Response to Planning Application

Application ref: BR/221/20/PL

Description: Detached garage with 1 No. flat above. This application is in CIL Zone 4 and is CIL Liable

Location: 5 Richmond Avenue Bognor Regis PO21 2YE

Drawing Title:
PROPOSED SITE PLAN

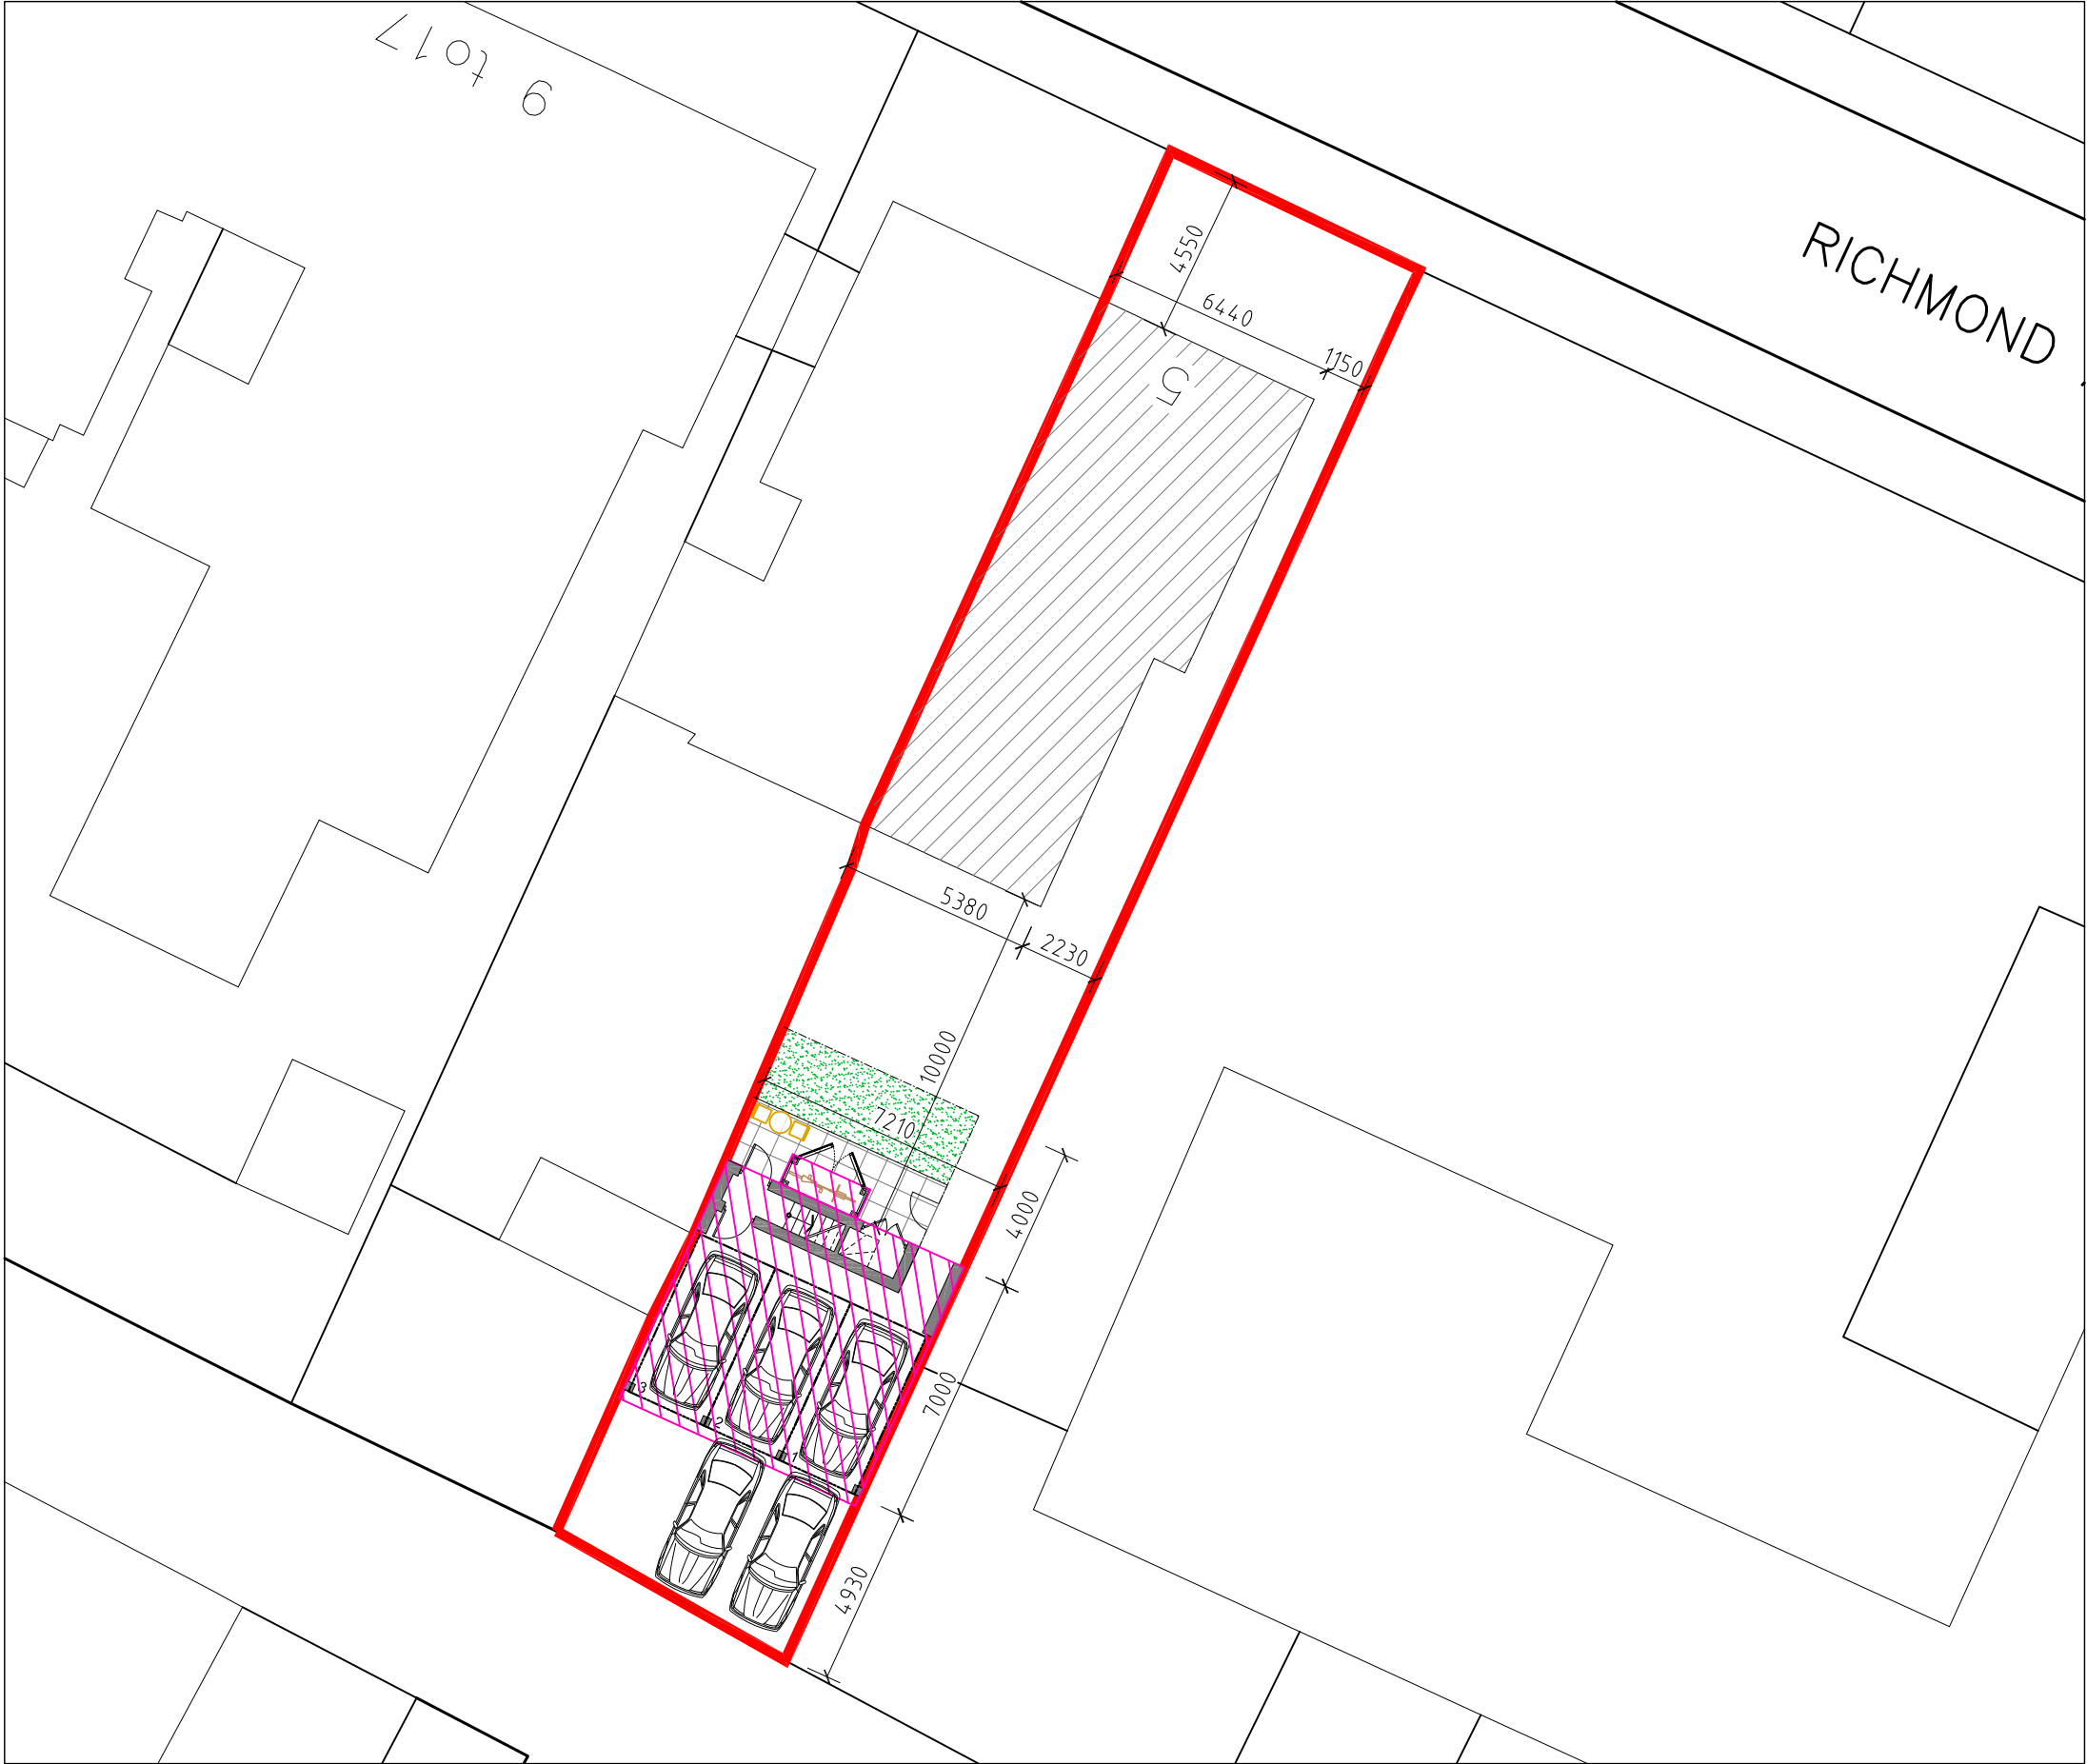
The NPPF para 124/127 relate to good design principles which equally apply to small infill and replacement development. The site layout plan has made reference to indicative proposed feature planting area. These details would require detailing in the submission of a planting plan detailing species choice, actual plant quantities, planting densities and size at time of planting.

Landscape provision to the garage frontage as required. All proposed planting should be considered and its connection for biodiversity and habitat explored, with a biodiversity net gain following development. Plants specified should be at a size which allow instant impact, but which will establish and mature as the site develops.

I would recommend no landscape objection to the proposals subject to submission of landscape details.
